RE: Lot 1 Independence Place at Cheyenne Mountain Filing No. 1A – Ponds A & B

This letter is intended to provide documentation with the County inspection Staff that Ponds A and B facilities in Lot 1 Independence Place at Cheyenne Mountain Filing No. 1A have been constructed in general conformance with the approved pond designs. WestWorks Engineering has reviewed the final construction facilities and survey as-builts by others confirming the appropriate size and design. Based upon this information and information gathered during periodic site visits to the project during construction, WestWorks Engineering is of the opinion that these stormwater BMP's have been constructed in general compliance with the approved construction plans and specifications as filed with El Paso County.

DESIGNED BY: CDK
SCALE: AS SHOWN
JOB NUMBER: 91807
DRAWN BY: CDK
DATE: 04/21/21
SHEET: GR7 OF 10

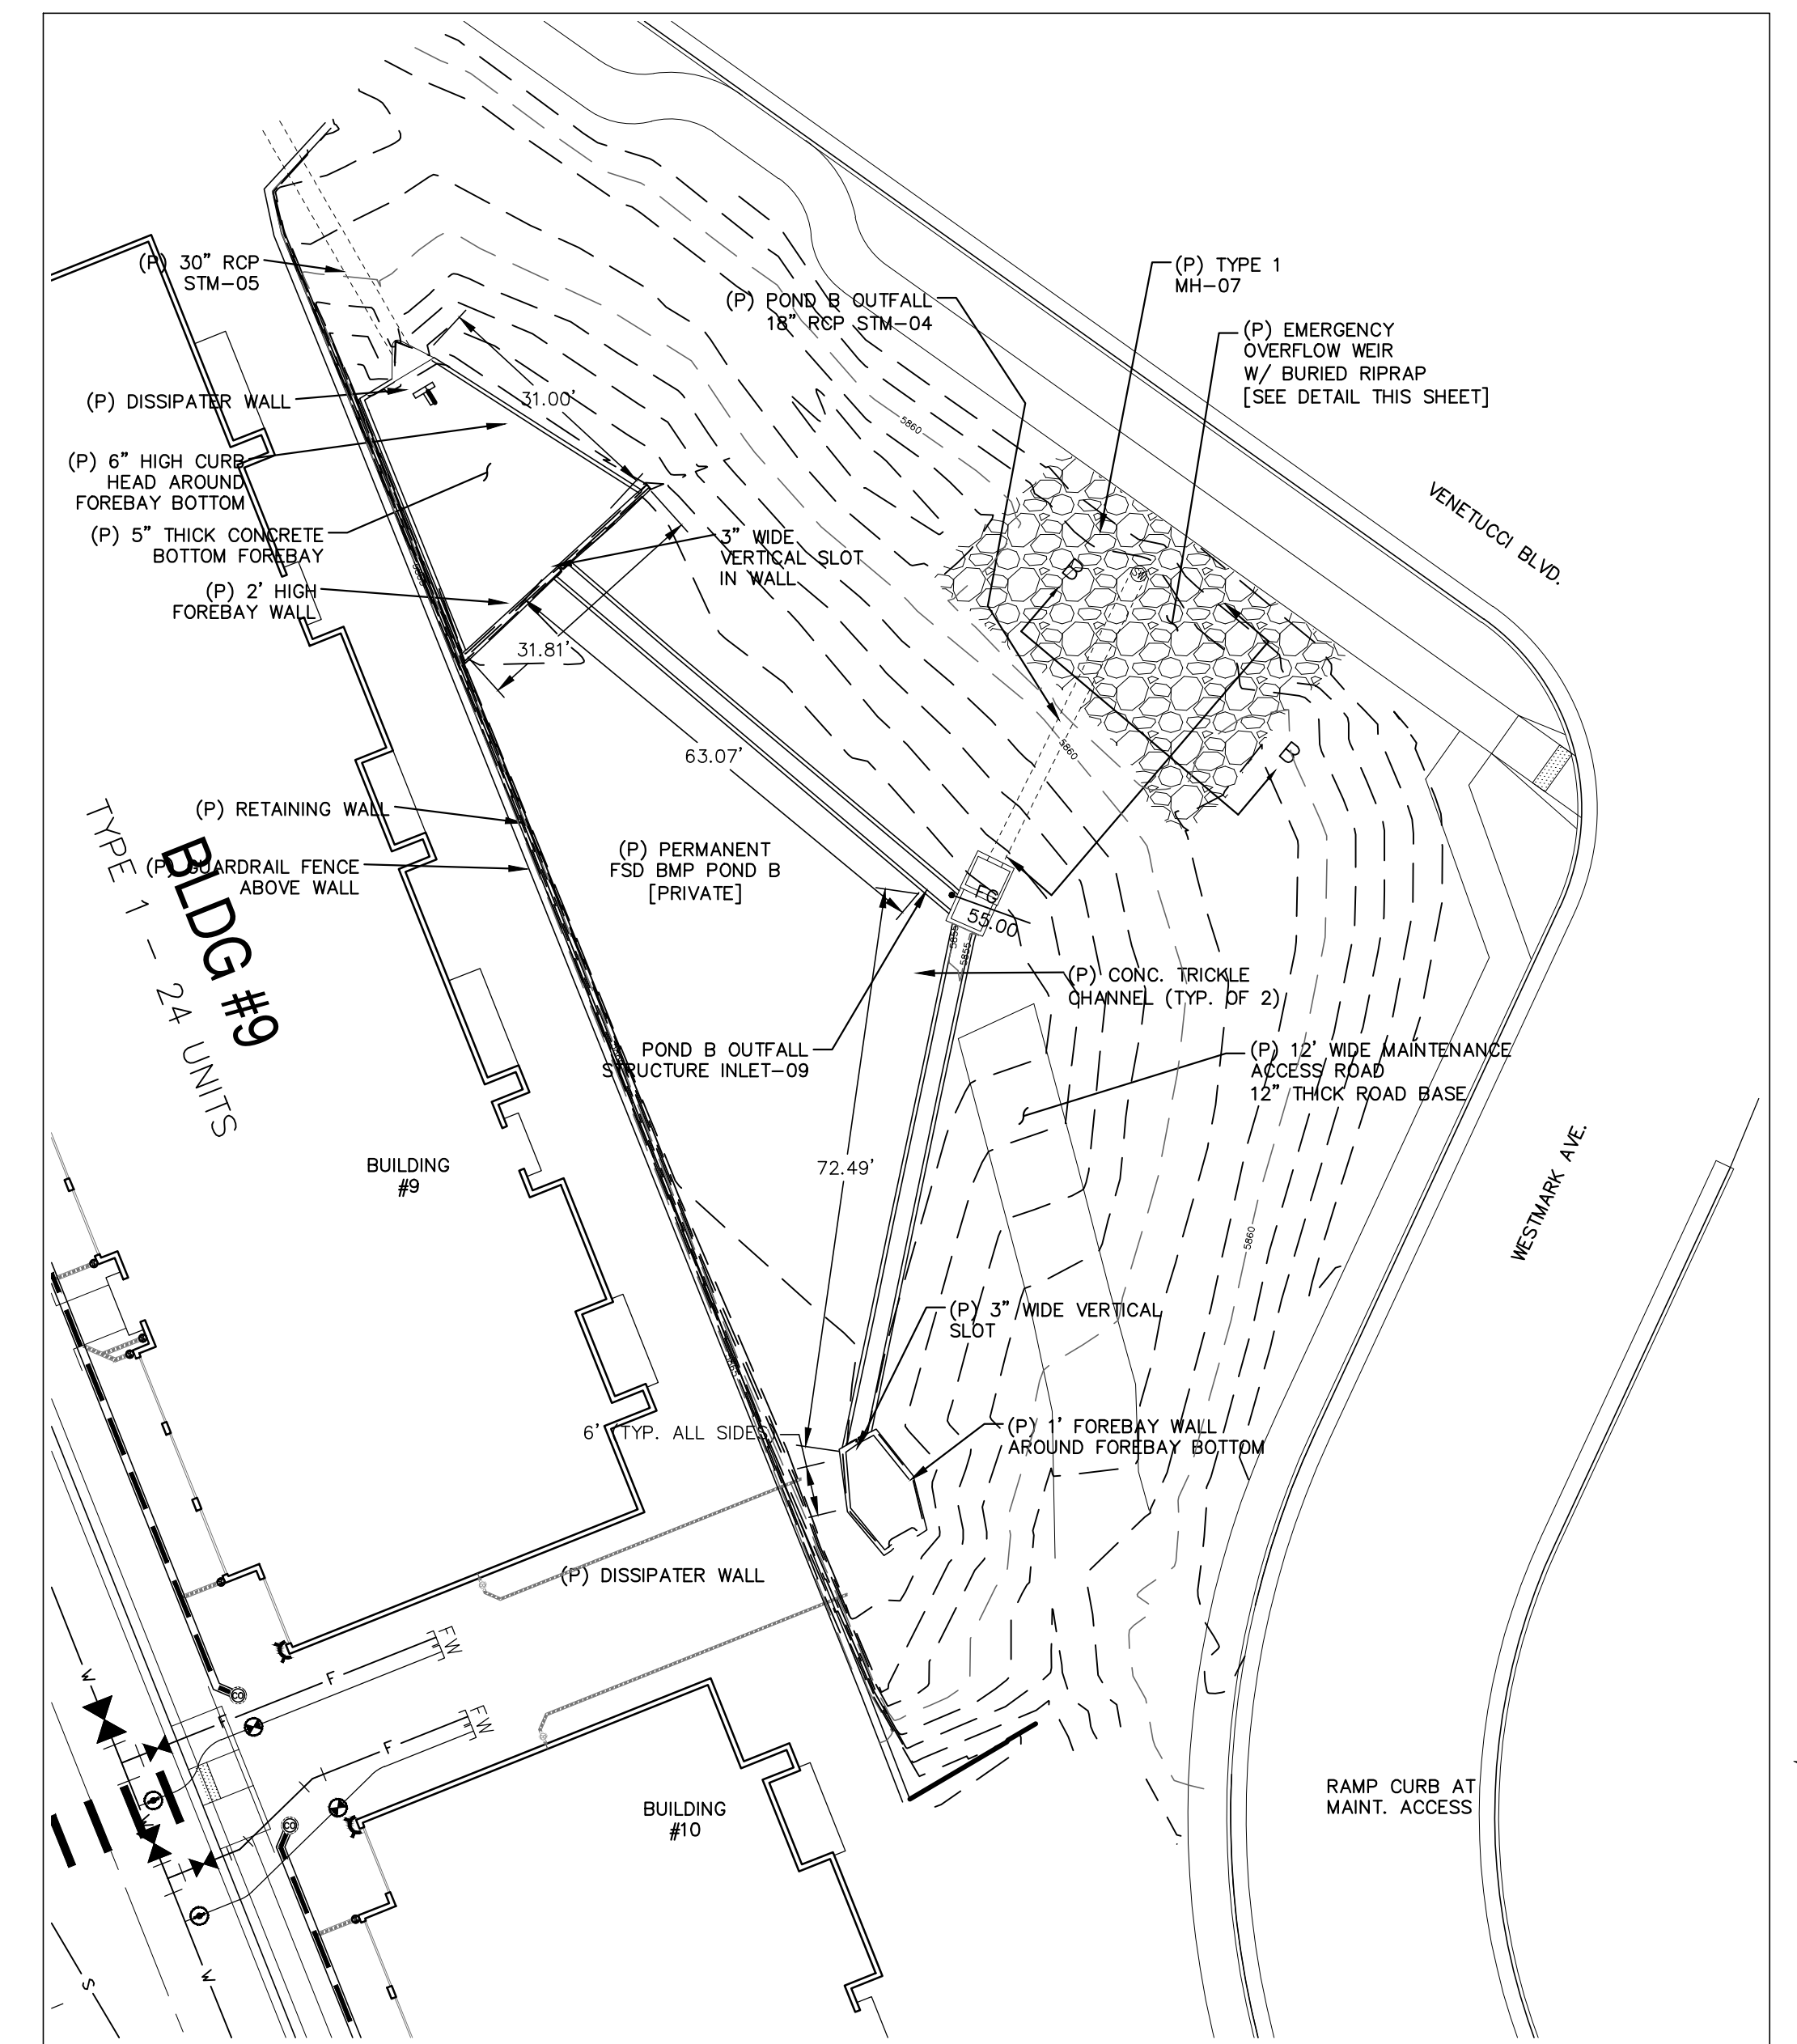
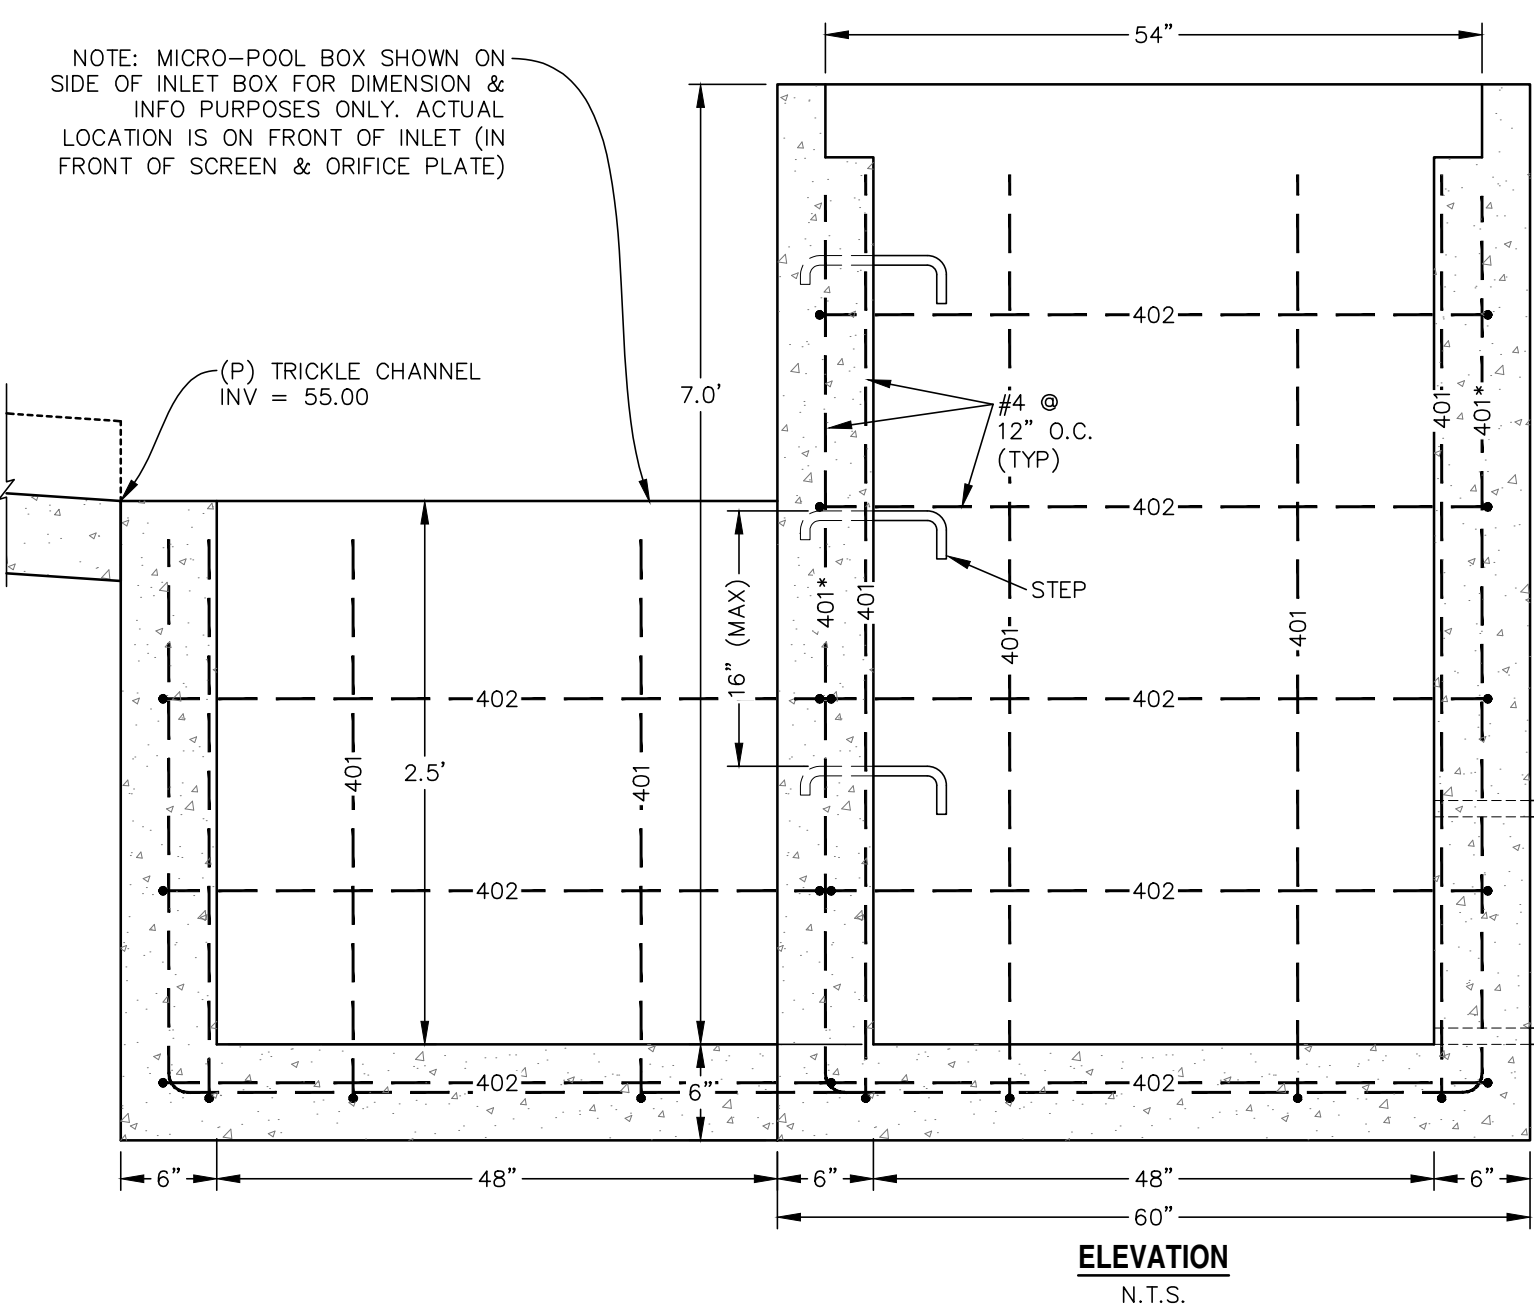
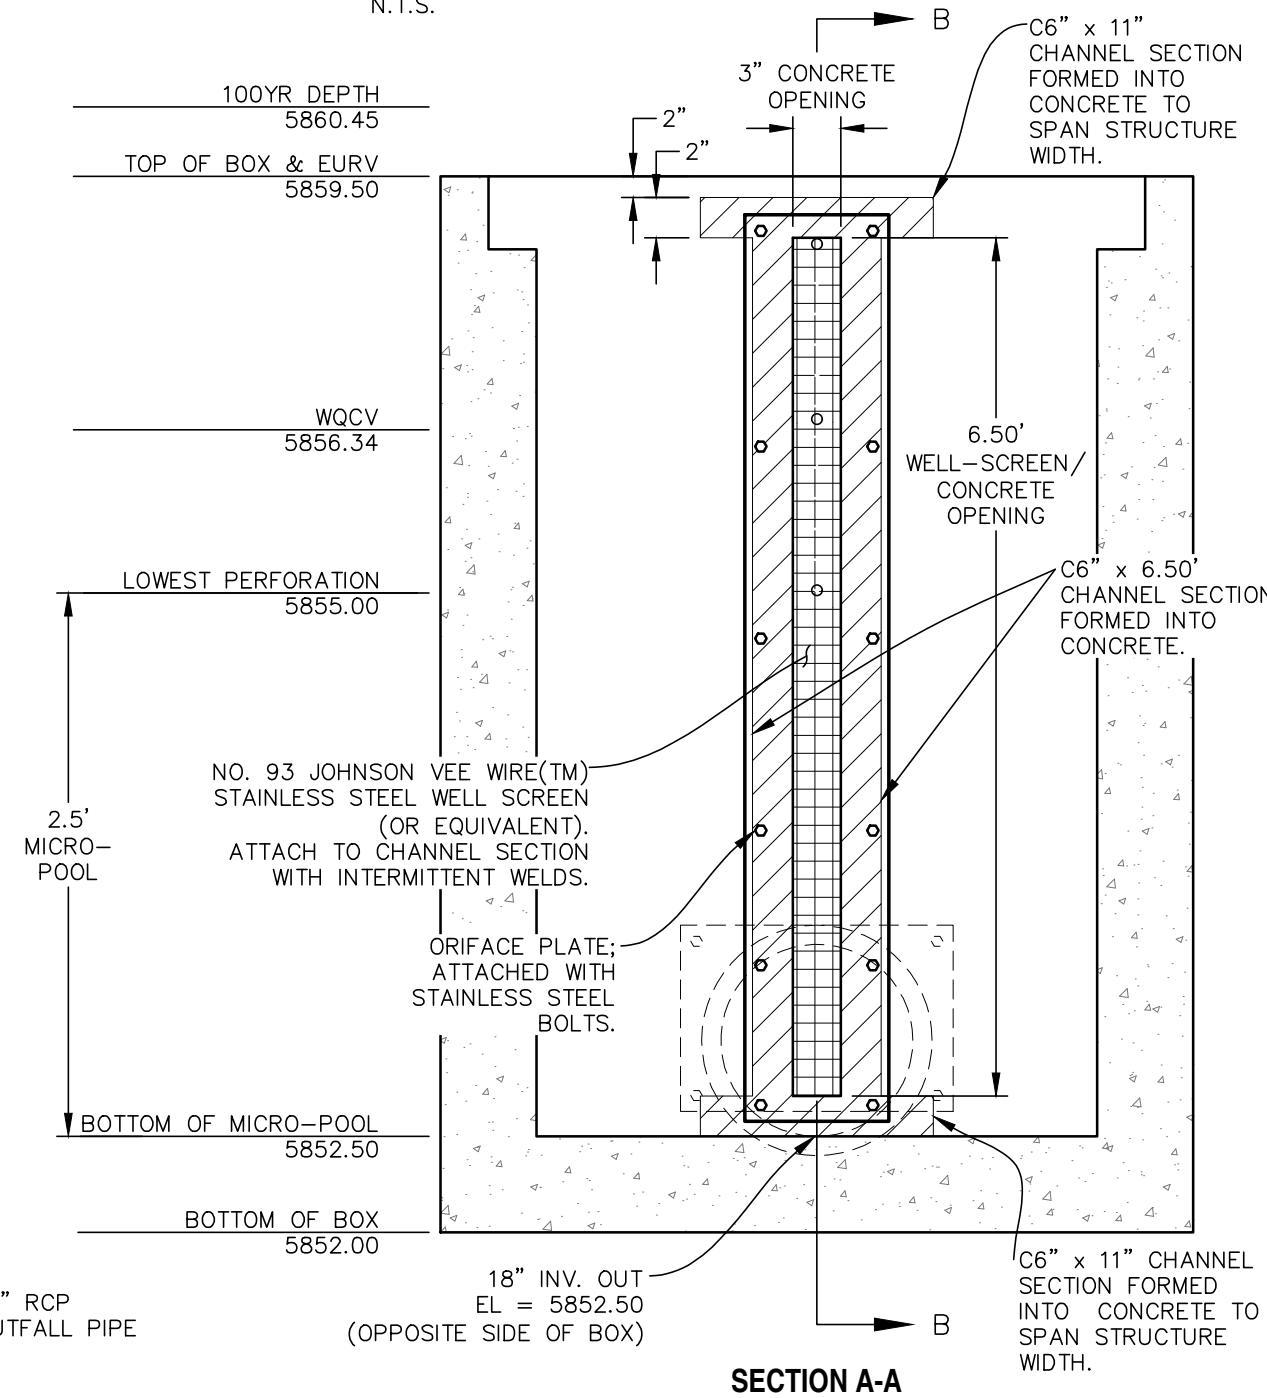
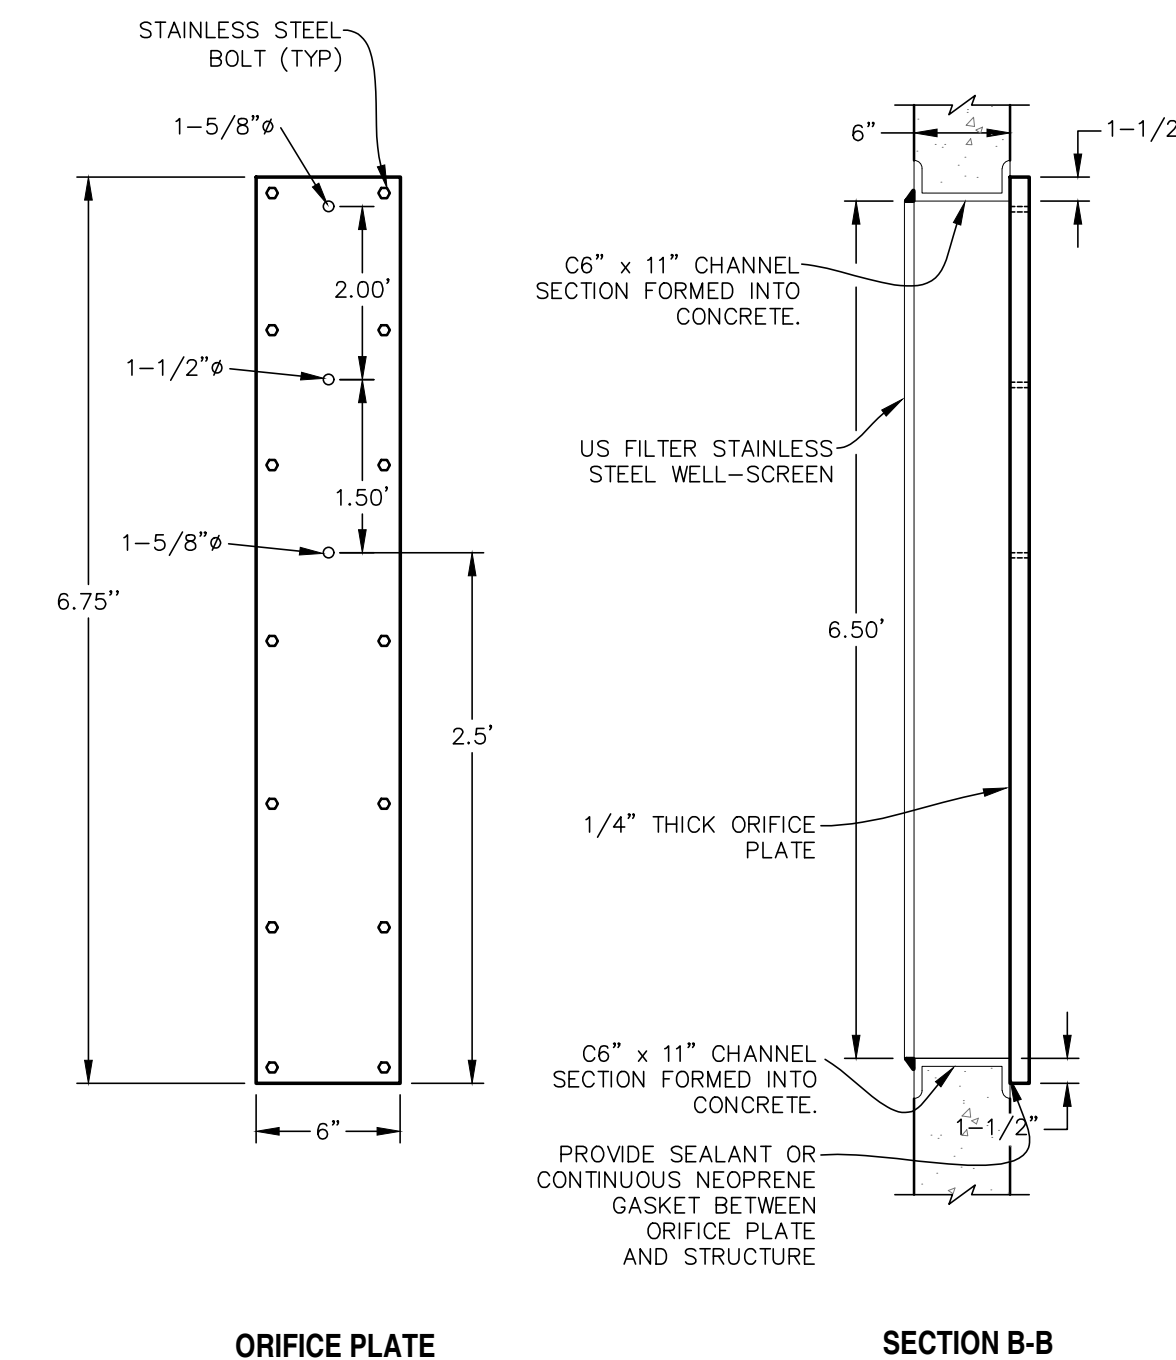
If any of the as-built changes to the pond design will effect the drain time:

Please update the MHFD-Detention Spreadsheet with the updated as-built information (pond elevations, spillway length, orifice hole elevations, etc.) to confirm that the pond is functioning as intended. The updated Spreadsheet should be attached to the Pond Certification Letter.

Include As-built condition stamp and EOR signature on each sheet. Per ECM 5.10.6 Engineering Record Drawings: Each sheet of the record drawings shall be designated as "Engineering Record Drawings" and signed and dated by the engineer of record.

Even if everything was built exactly per plan, we need an electronic PDF of the original drawings to be signed, dated, and stamped with "As-Built" on each sheet.

Differences from design to as-built conditions to be shown in red text with red clouds/bubbles.
